Odour Assessment Review
Land at Ford Airfield, Ford,
West Sussex
November 2021

Project no.	Project
8693C	Odour Assessment Review: Land at Ford Airfield, Ford, West Sussex

Client	
Arun District Council (ADC)

Report No.	Version	Prepared by	Checked by	Authorised by	Date of issue
11050	V0	H. Parfitt	P. Beckett	P. Beckett	19/11/2021

## Appendix B – Walkover Surveys: Locations

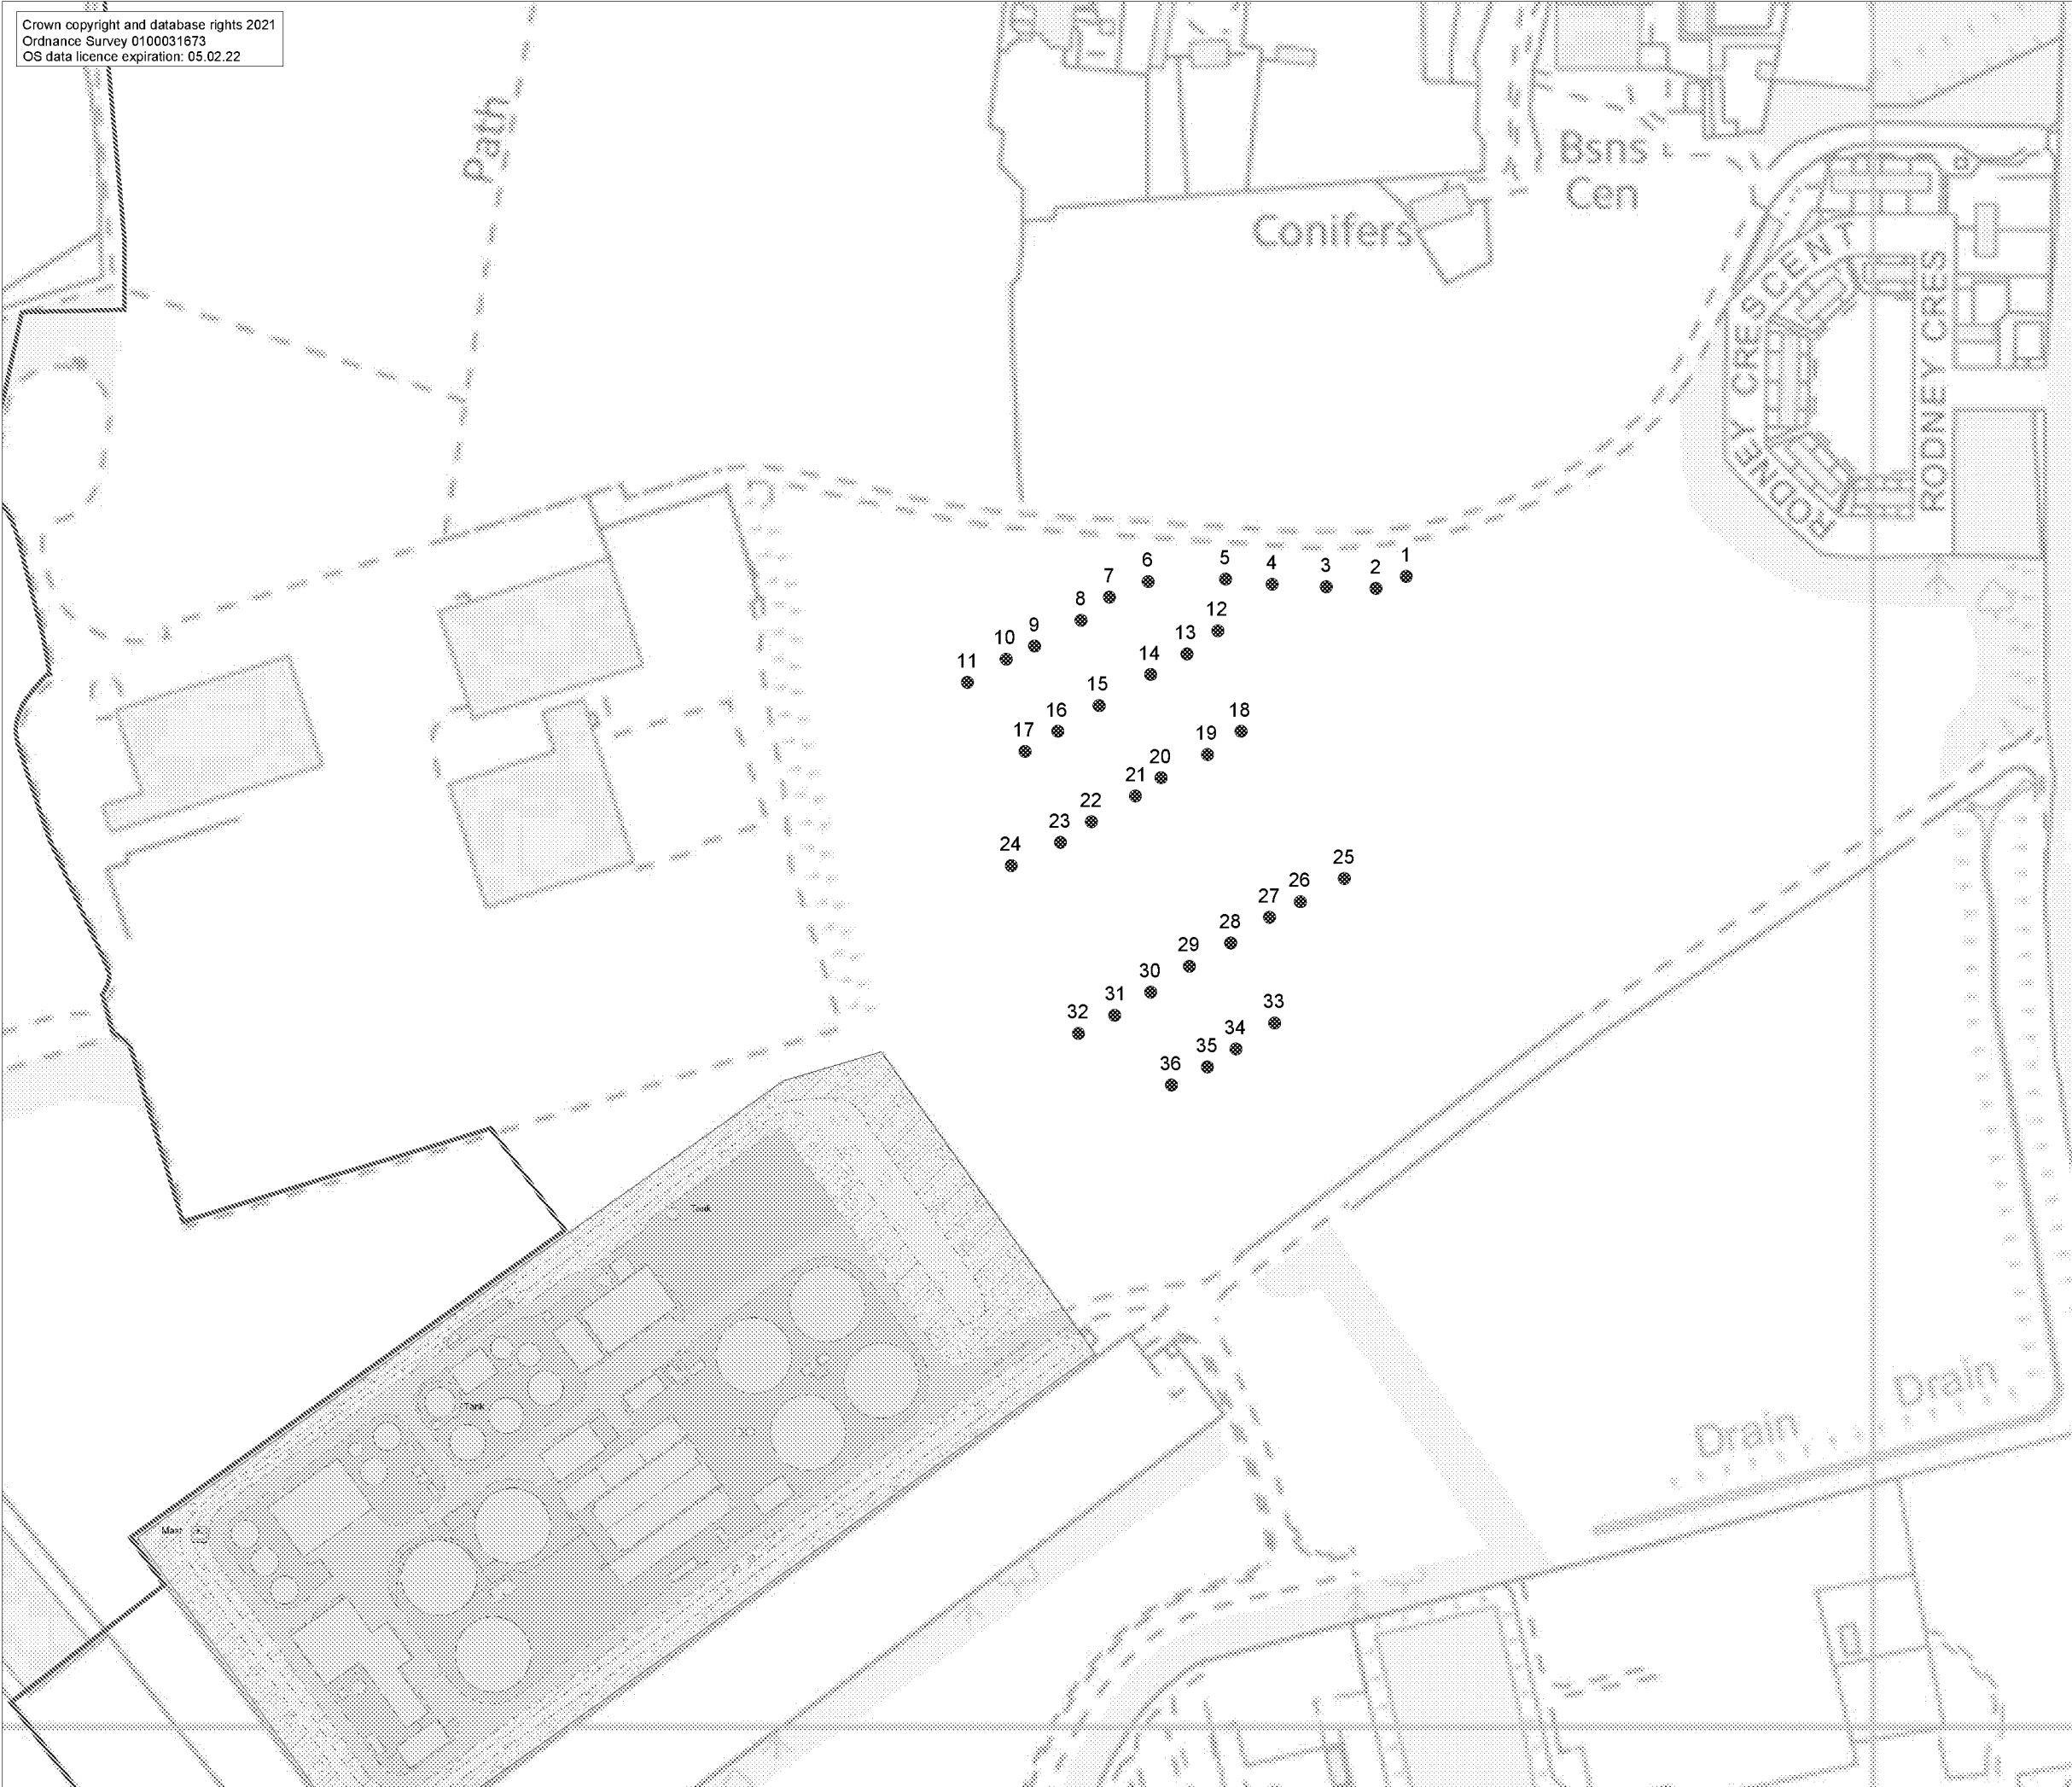
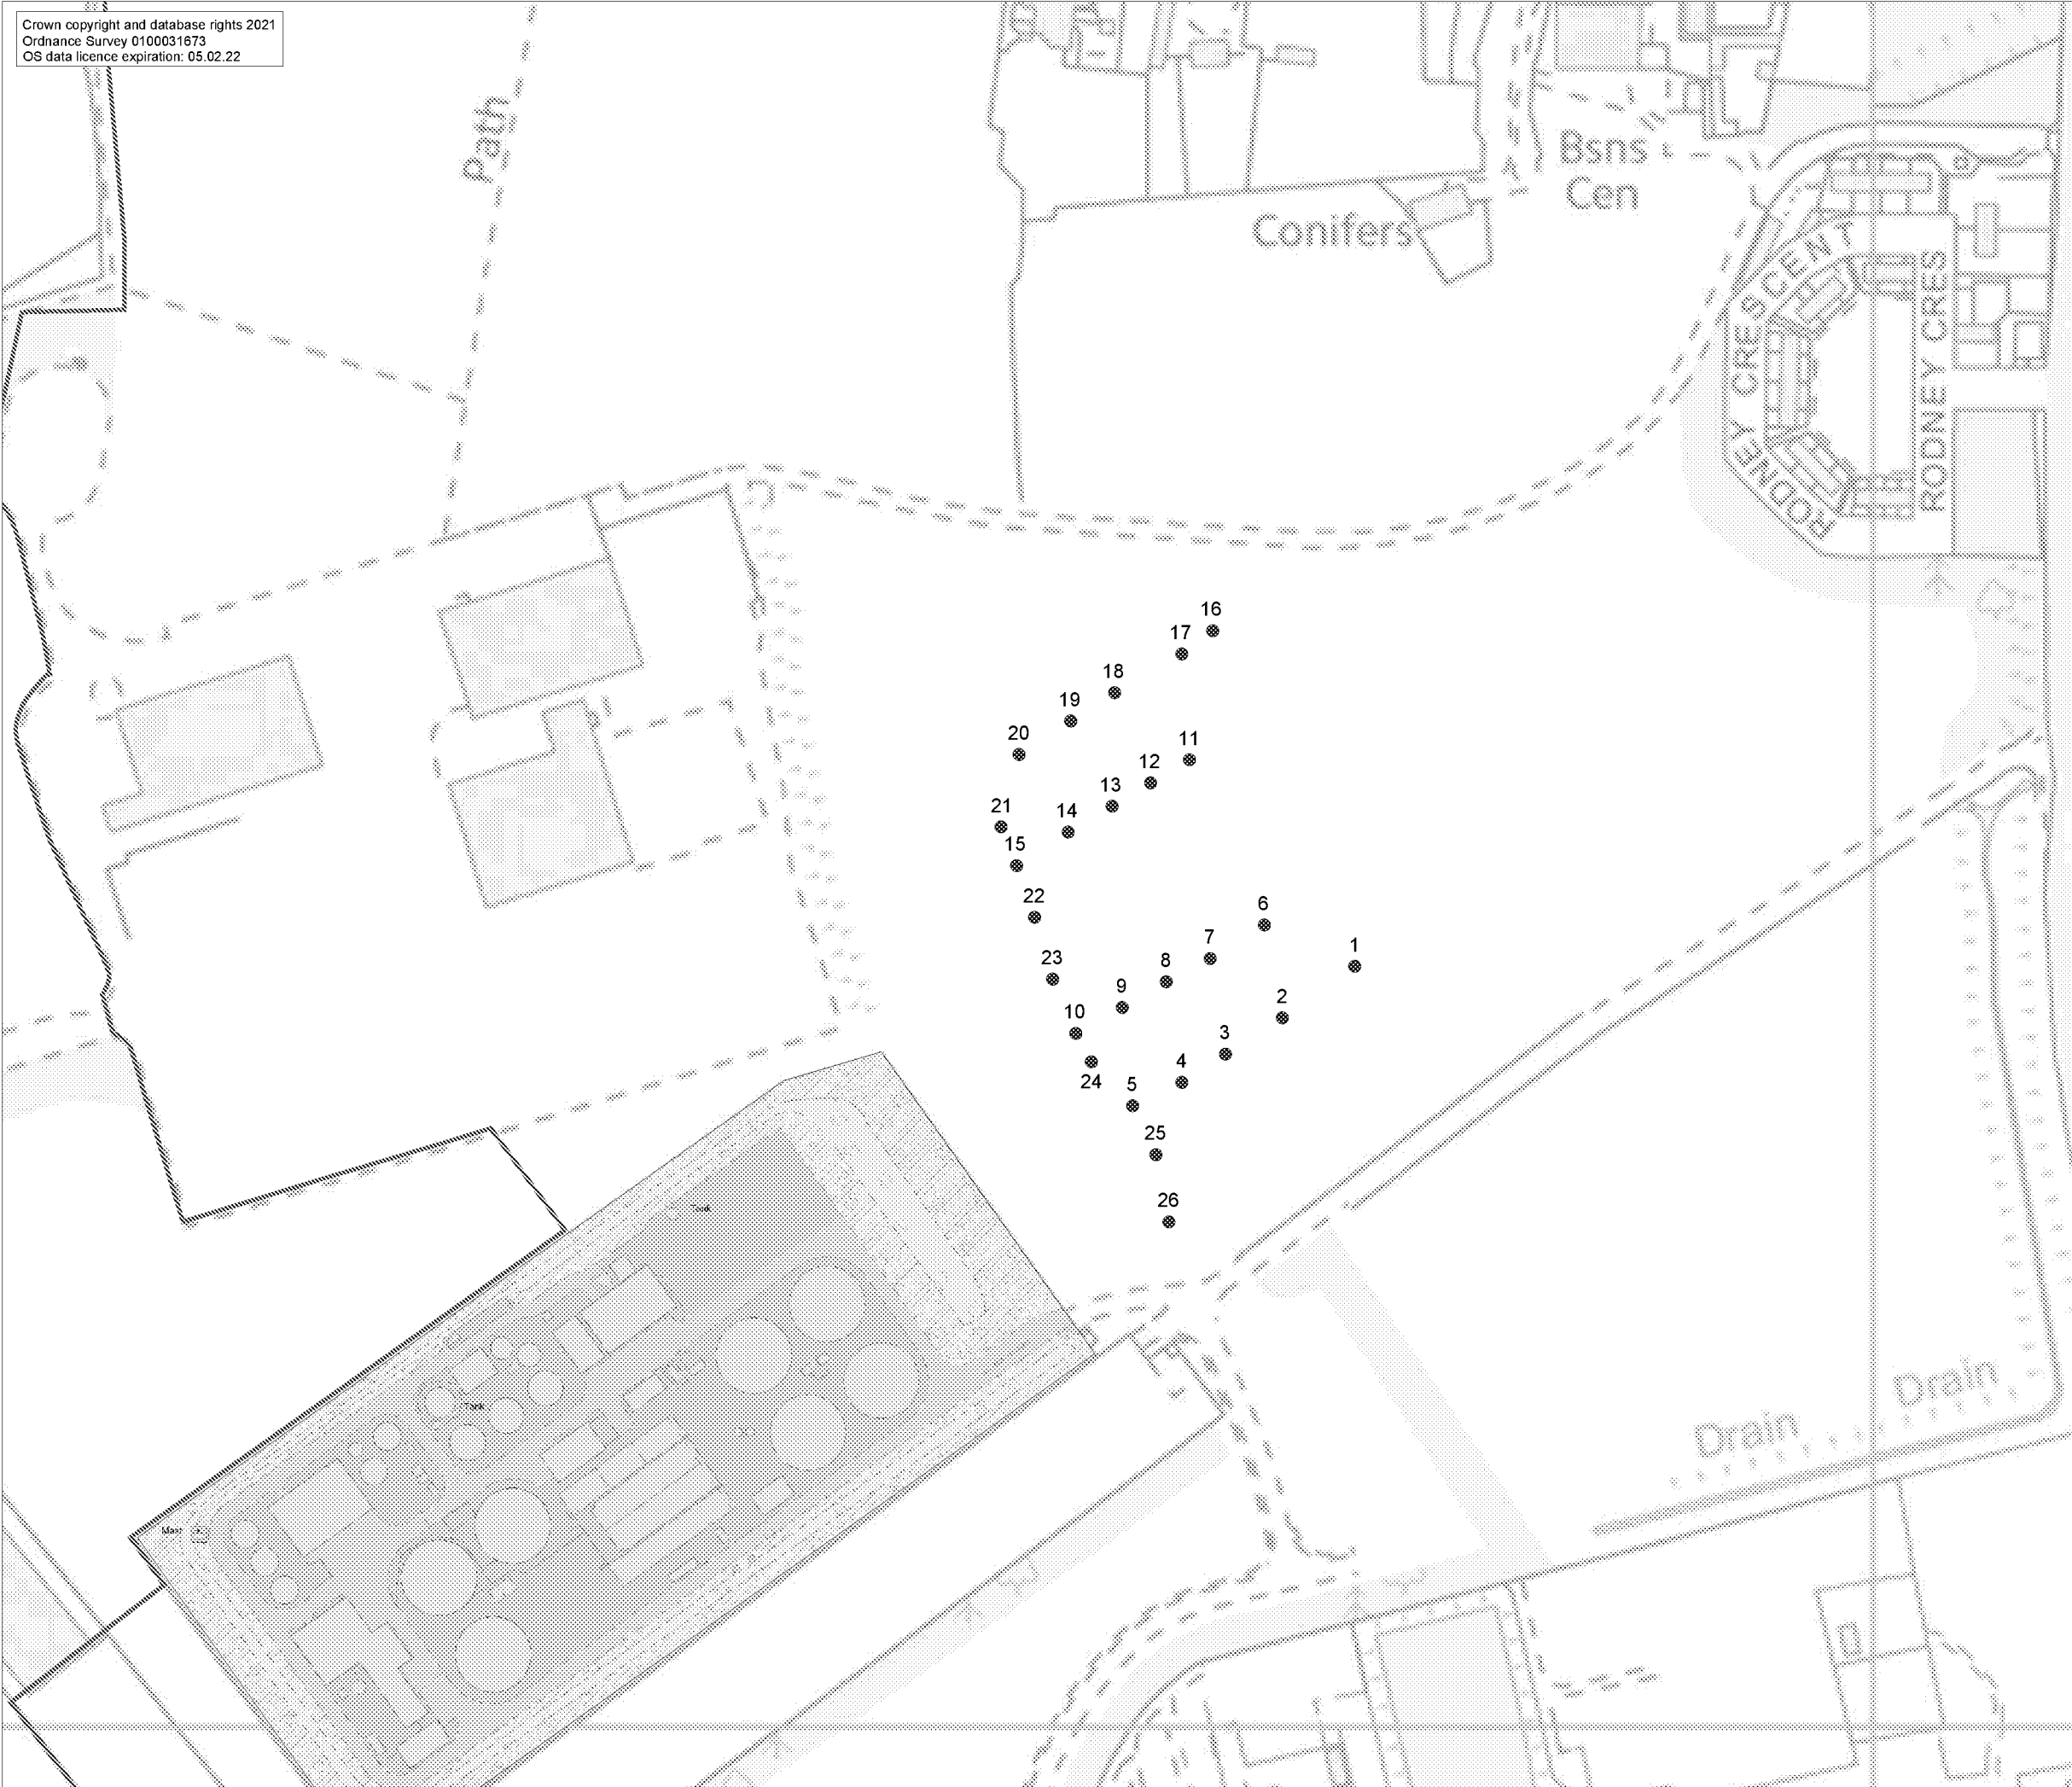
- 2.30 During walkover/sniff test 1, strong odours could be detected transiently but regularly up to 120m from the WwTW boundary, and at least 300m from the most odorous part of the WwTW, i.e., the main works odour control unit. The three locations where strong odours could be detected were not the three closest, as is suggested in the report, suggesting that a plume from the OCU might be grounding there.

- 2.31 Nevertheless, there is consistency in the results of the sniff tests (i.e., that the area within 100m of the WwTW to the NW is regularly exposed to strong odours that could be *"regarded as 'substantial adverse' for a residential receptor and 'moderate adverse' at a commercial receptor"*. This area is at least 300m from the most odorous part of the WwTW, i.e., the main works OCU.

- 2.32 During sniff test 3, strong odours could regularly be detected along the WwTW southern boundary (locations 5 to 14); however, strong odours quickly dissipated when sampling at locations 22-29, which were circa 70m to the south. The sniff test did not sample at greater distances to the south. It is, therefore, unknown whether odours could be detected at 300m distance from the main OCU, as they could be to the north-east of the WwTW. This is a possibility given the height and design of the OCUs, which would allow odorous air to ground at greater distances from the facility.

- 2.40 For example, the sniff tests find that moderate & substantial adverse impacts (assuming residential uses were present) could be consistently detected to the north-west of the WwTW up to 100m from the site boundary, and over 300m from the most odorous part of the WwTW. However, the modelling suggests impacts would be, at worst, 'slight adverse' at this location. This suggests that impacts associated with normal operations of the WwTW could be under-predicted to the north-west of the facility and that the model is not performing in line with the prevailing meteorological conditions and with the ground based observations.
